From: Laura Gibbons <Laura.Gibbons@arun.gov.uk>
Sent: 08 June 2021 12:33
To: Planning.Responses <Planning.Responses@arun.gov.uk>
Cc: Michael Eastham <Michael.Eastham@arun.gov.uk>
Subject: a/31/21/pl- land south of water lane angmering

We wish to object to this application. The proposed landscaping plans show significant conflict between drainage and planting proposals. Drainage must be considered with landscaping proposals.

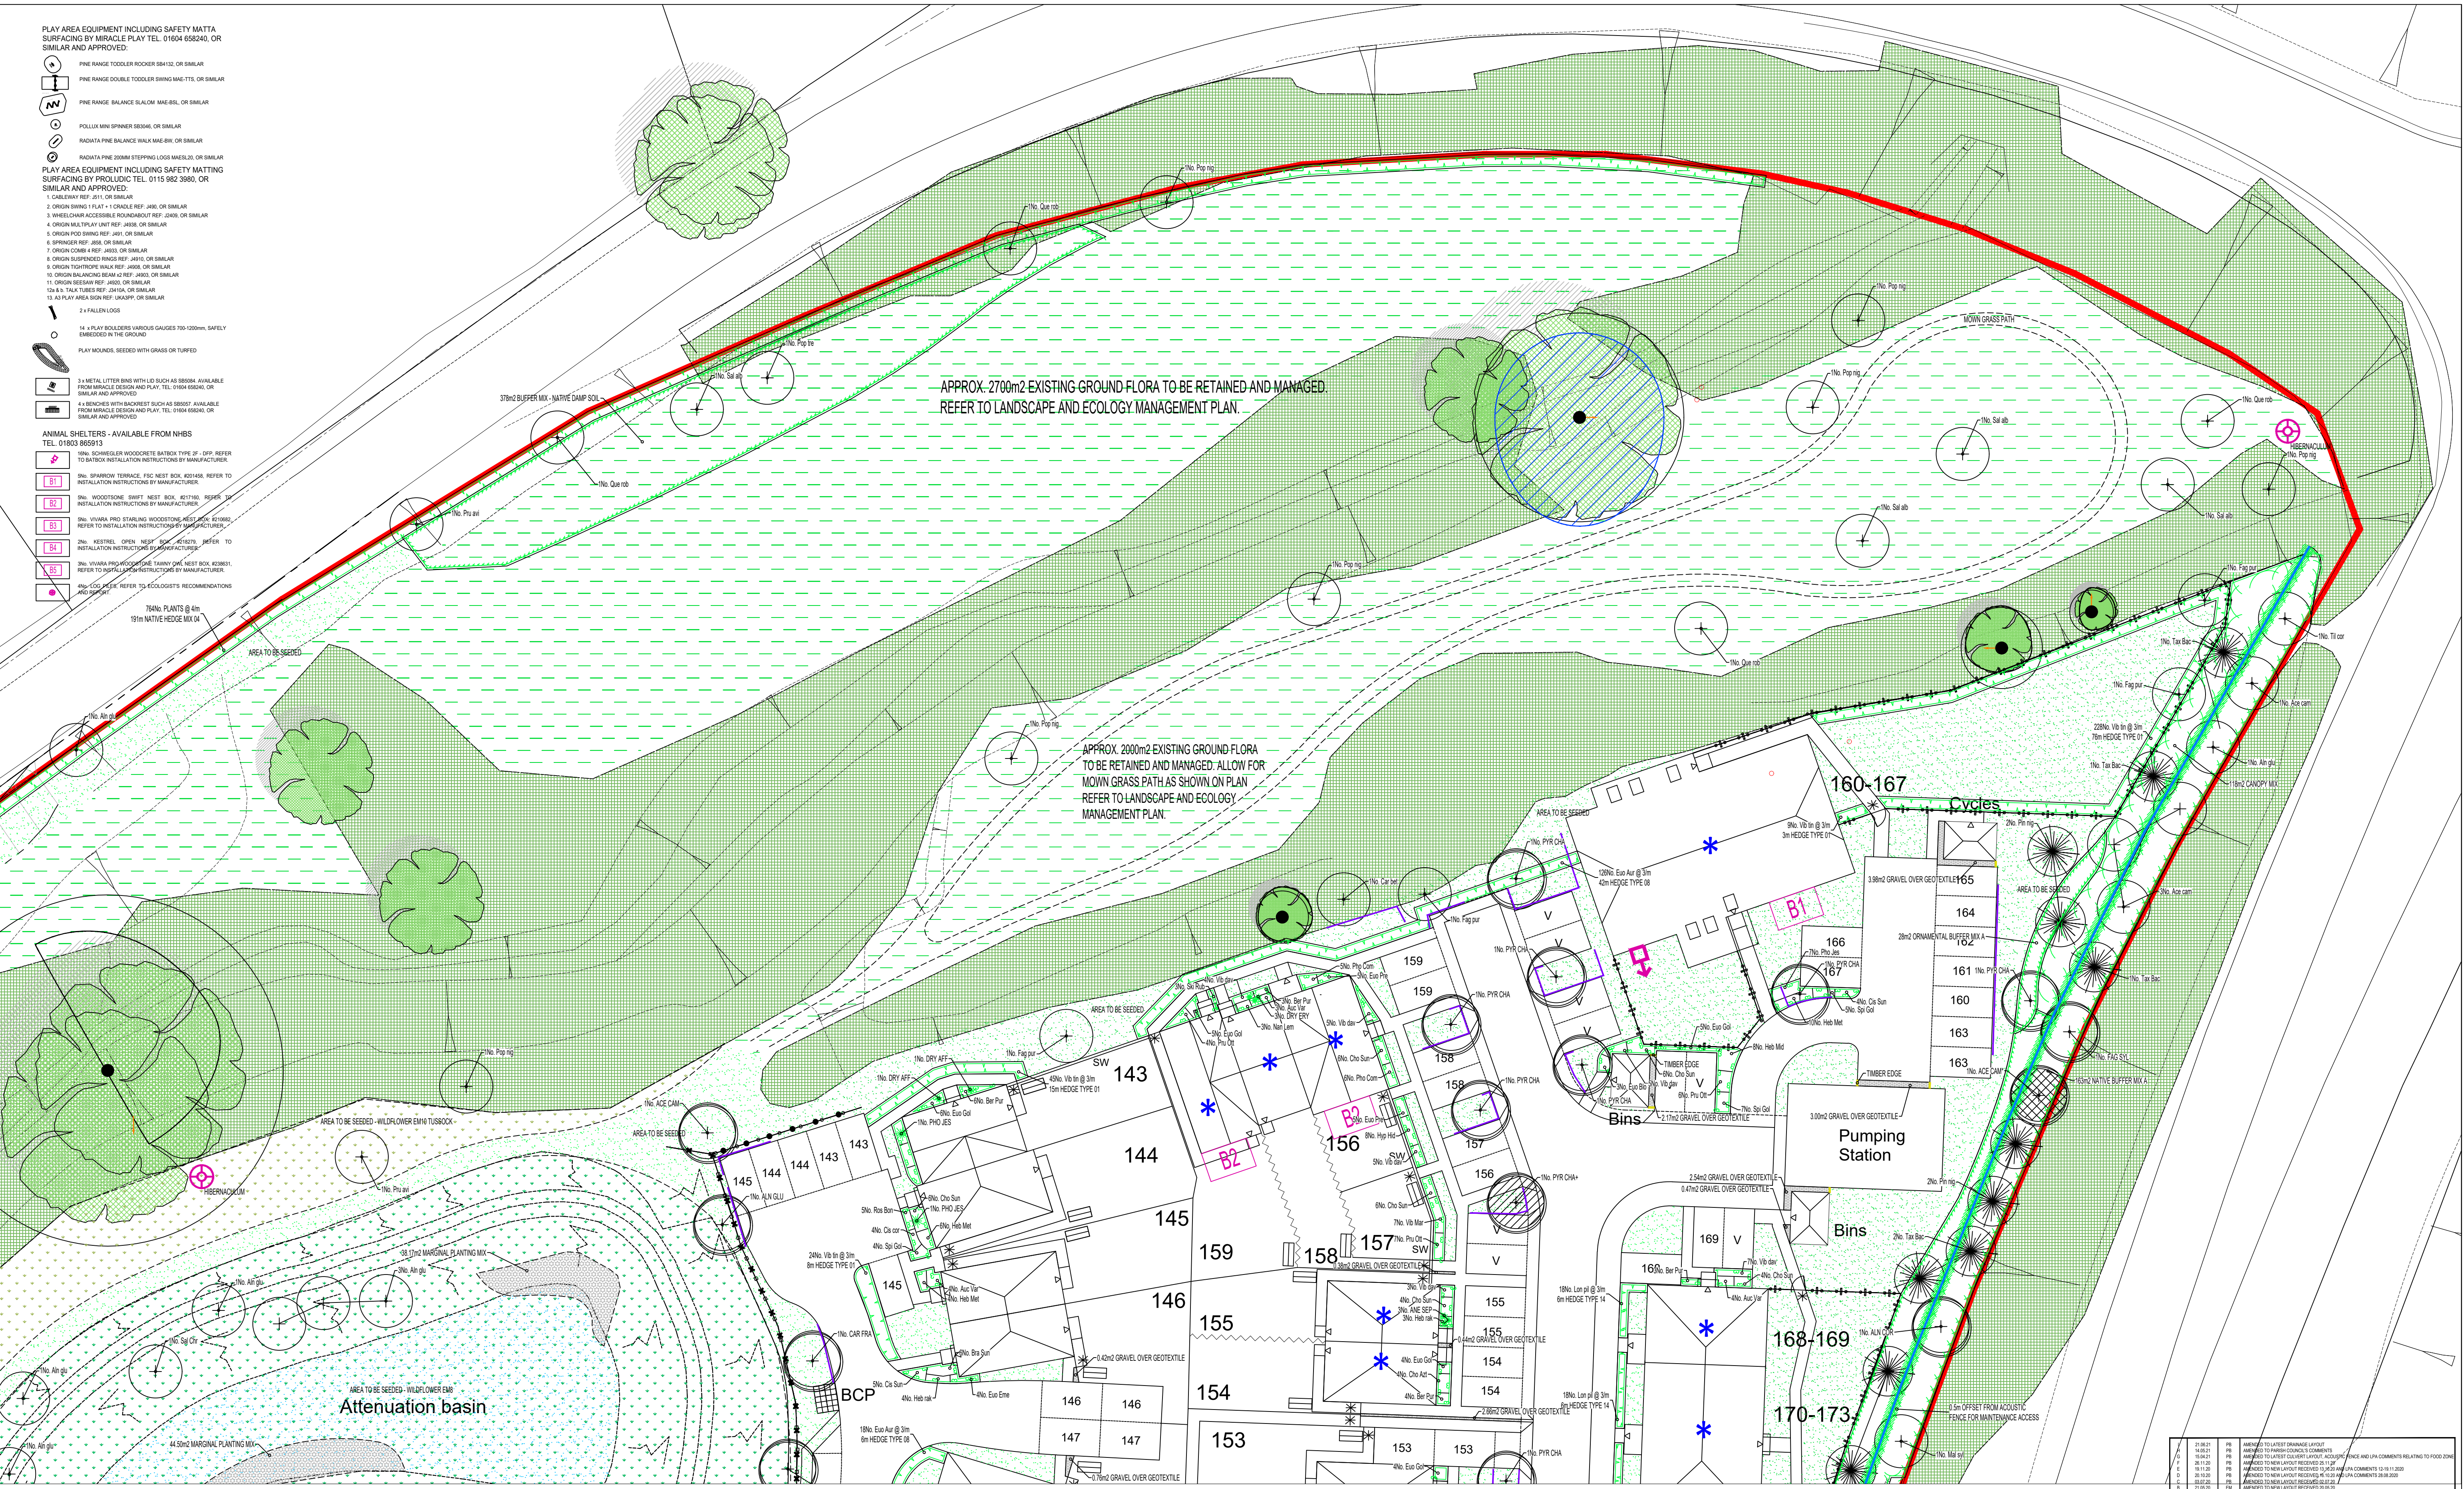
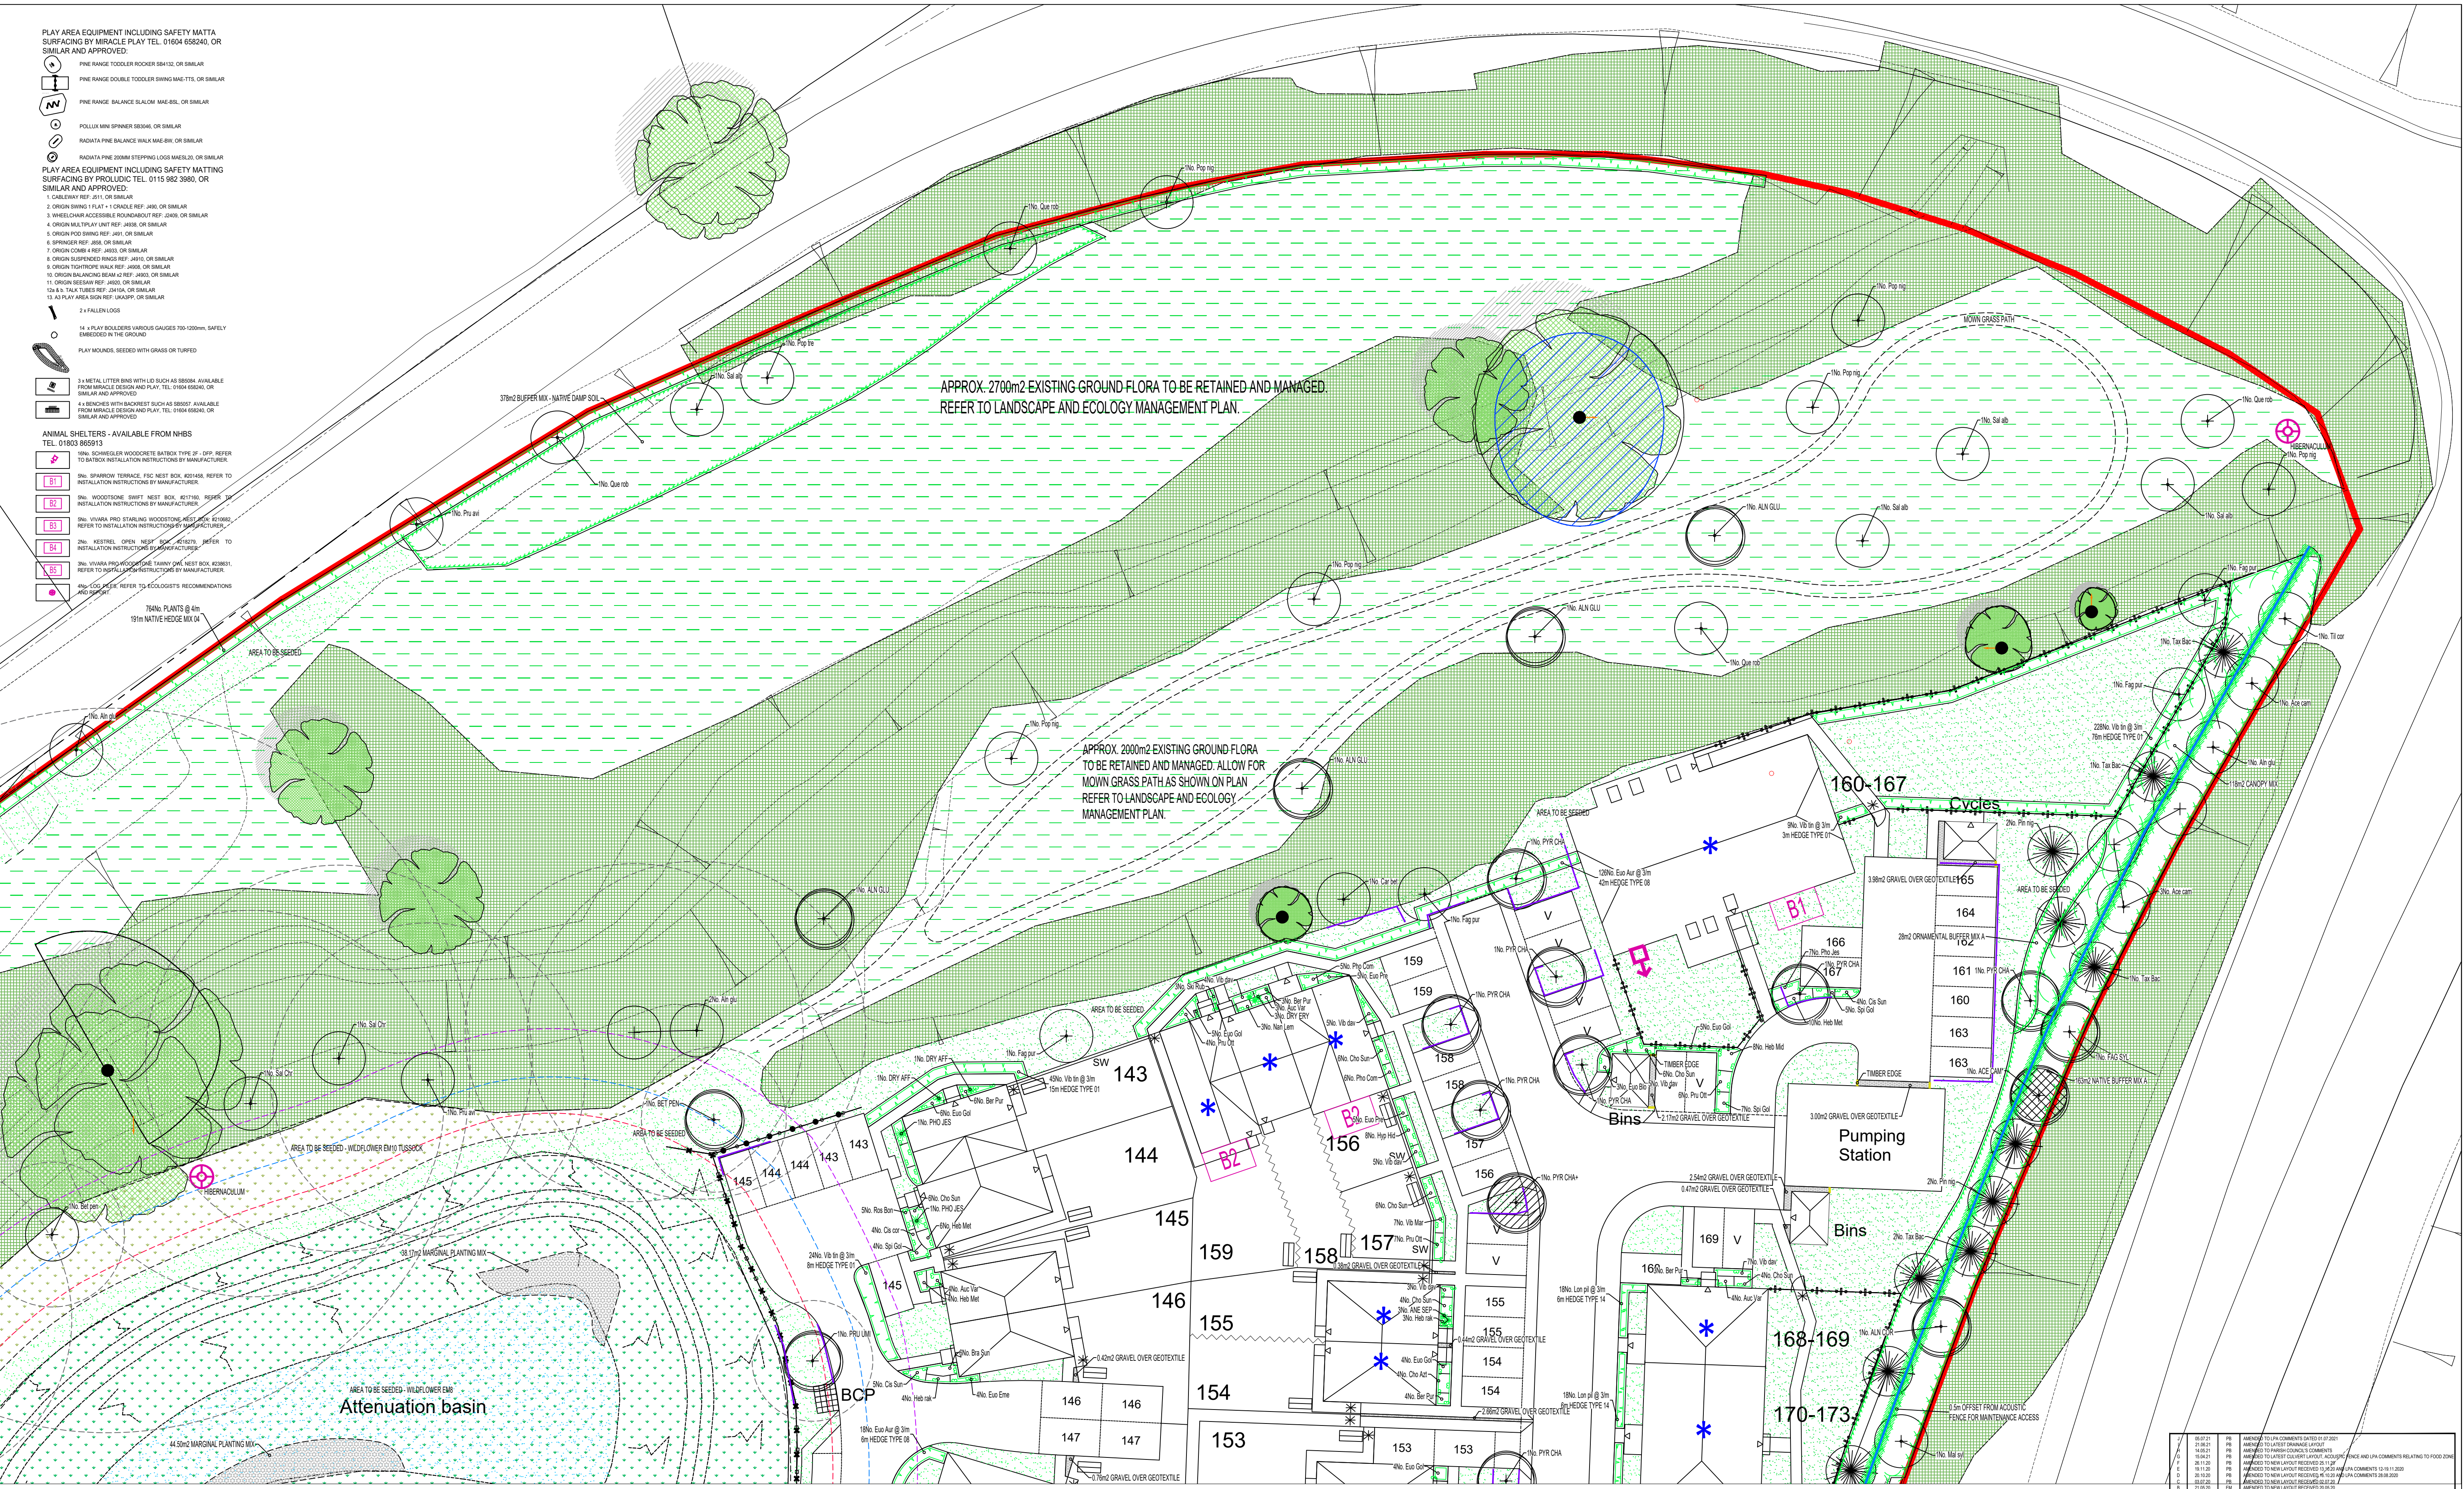
Please can the applicant supply plans which show tree root potential areas and drainage. Trees must not be proposed within or in close proximity to attenuation features. Please ensure that trees are sufficiently positioned so that their root potential areas are not in conflict with drainage features, especially lined features. Southern water have a useful planting guide which the applicant may wish to refer to.
